RE: Planning Application: FG/198/16/PL : 1 Sea Drive, Ferring

RE: Planning Application: FG/198/16/PL : 1 Sea Drive, Ferring

With reference to the above planning application and our subsequent telephone conversation, please find attached a copy of the updated plans revised in accordance with our discussions.

BASEMENT FLOOR PLAN

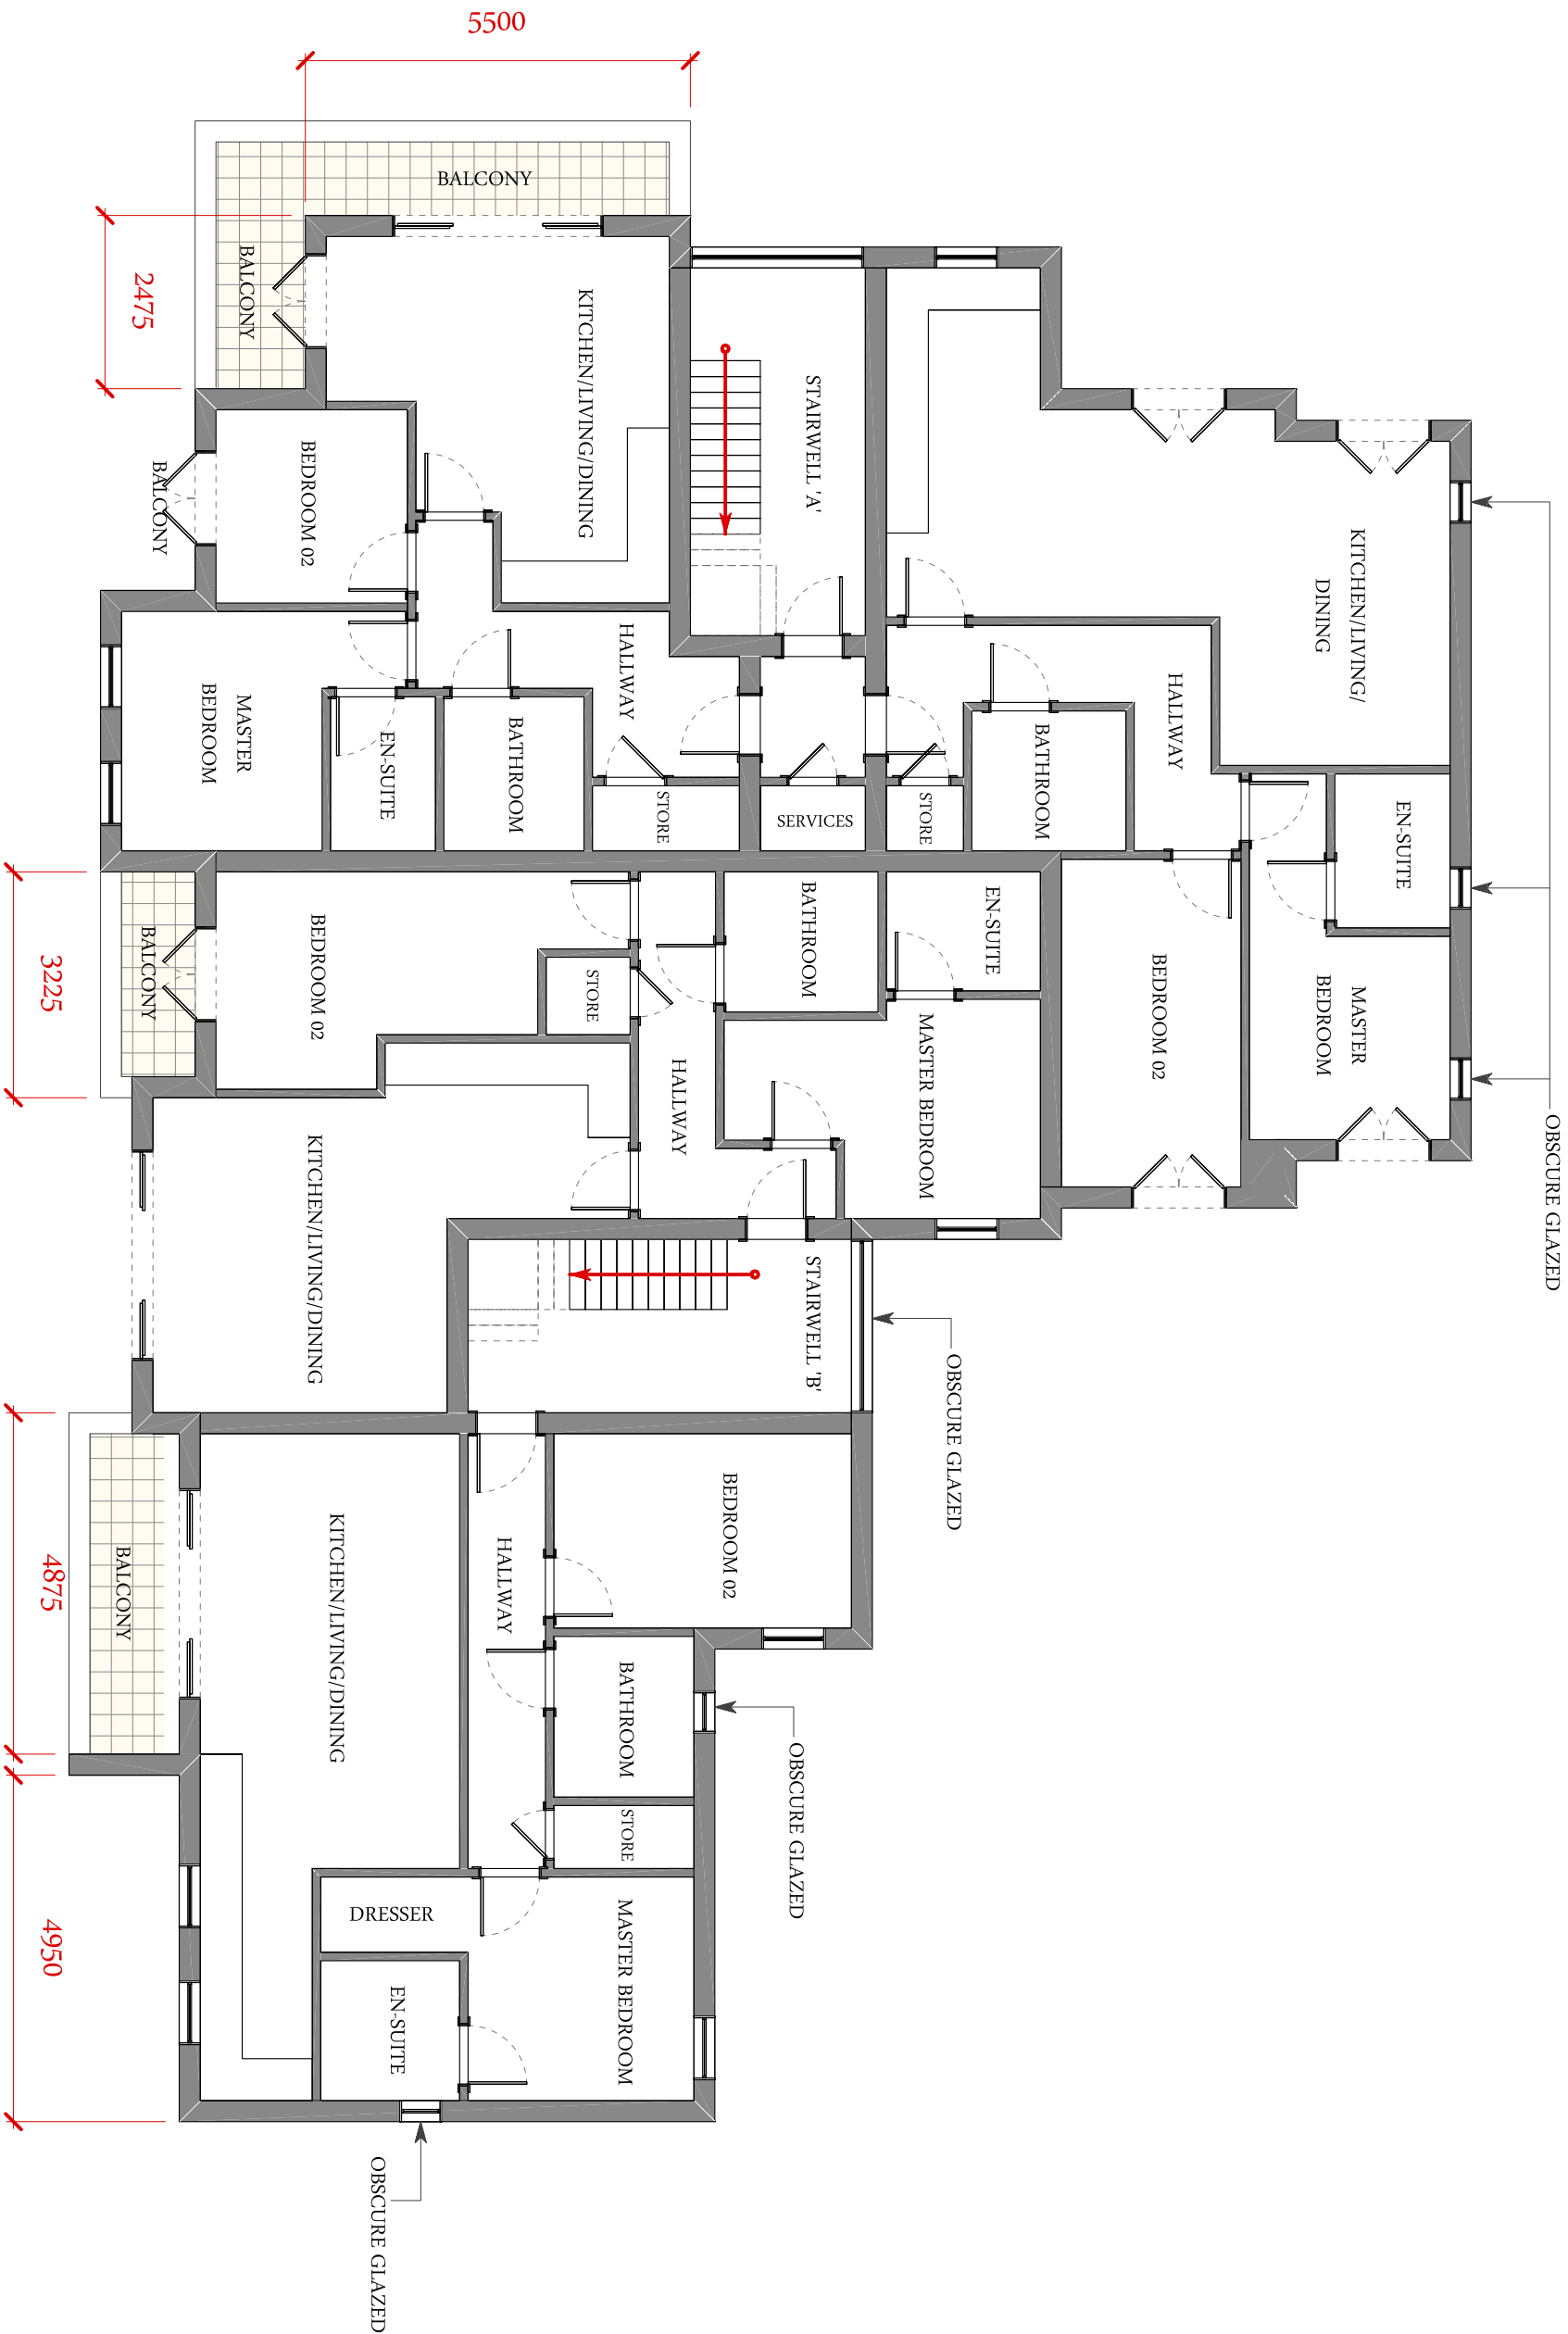
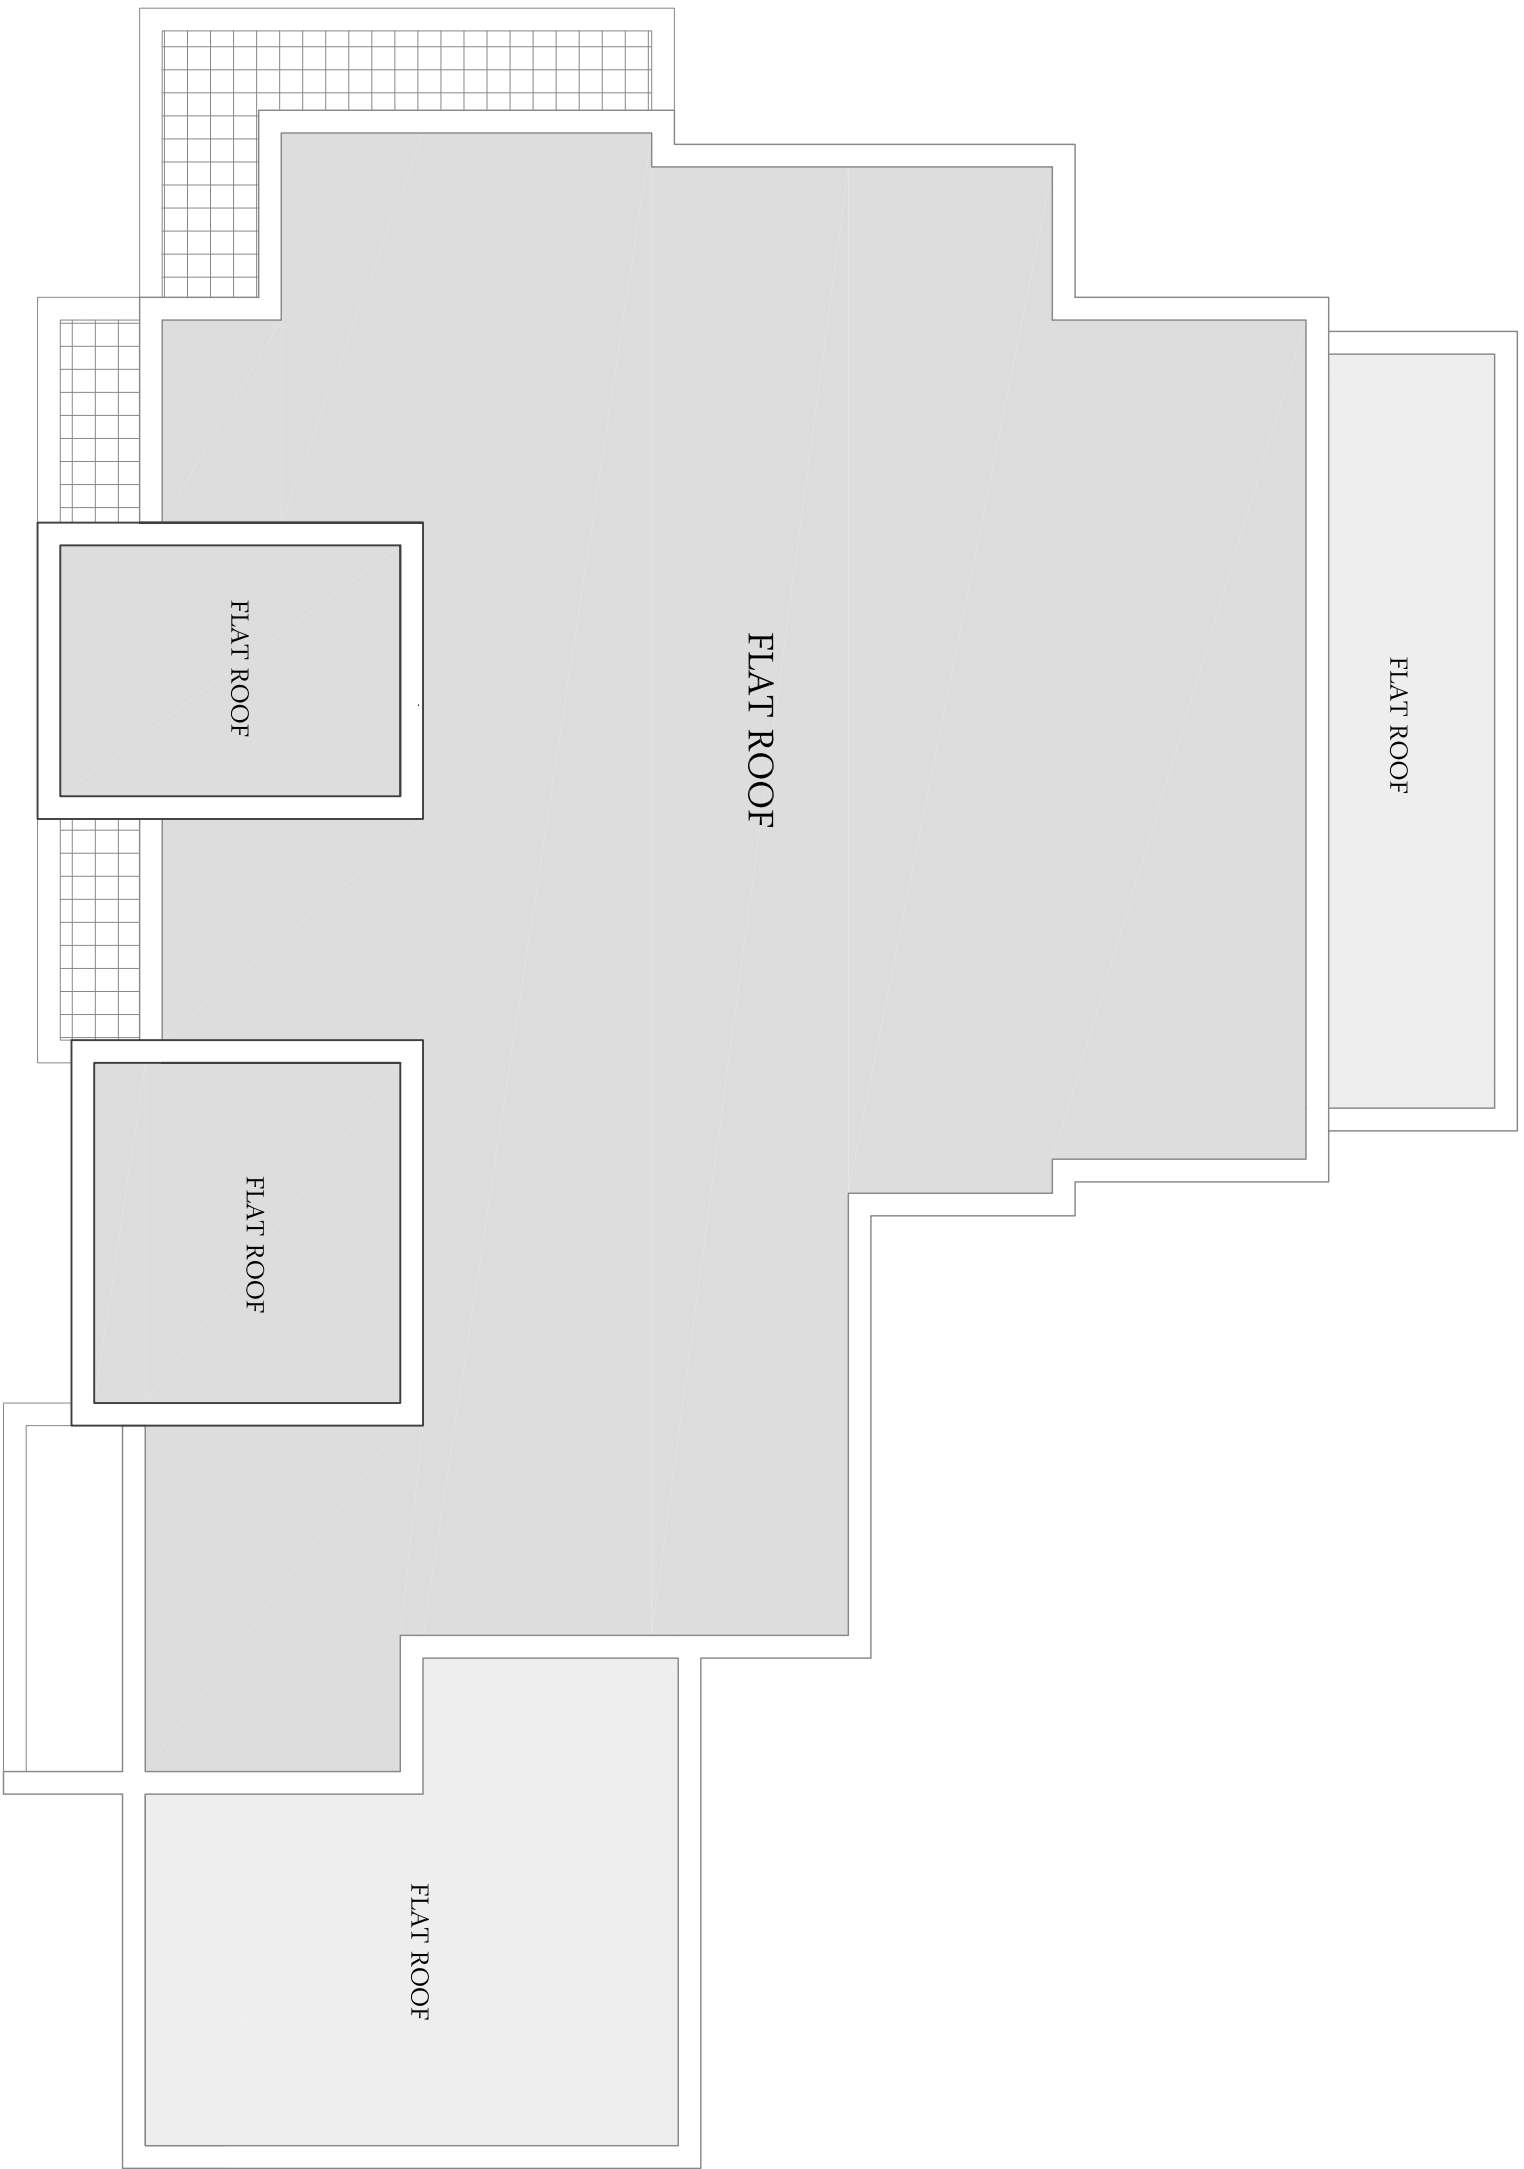
1. Introduce basement parking; we have achieved 8no parking spaces within the basement via a ramped access from the rear and 2no spaces above ground, total 10no parking spaces.
2. Reduce above ground hardstanding to enable increased soft landscaping to the boundaries adjacent to neighbouring properties.
3. Introduce low wall & railings with hedging to Sea Lane/Sea Drive frontage to match 'Blue Waters'.
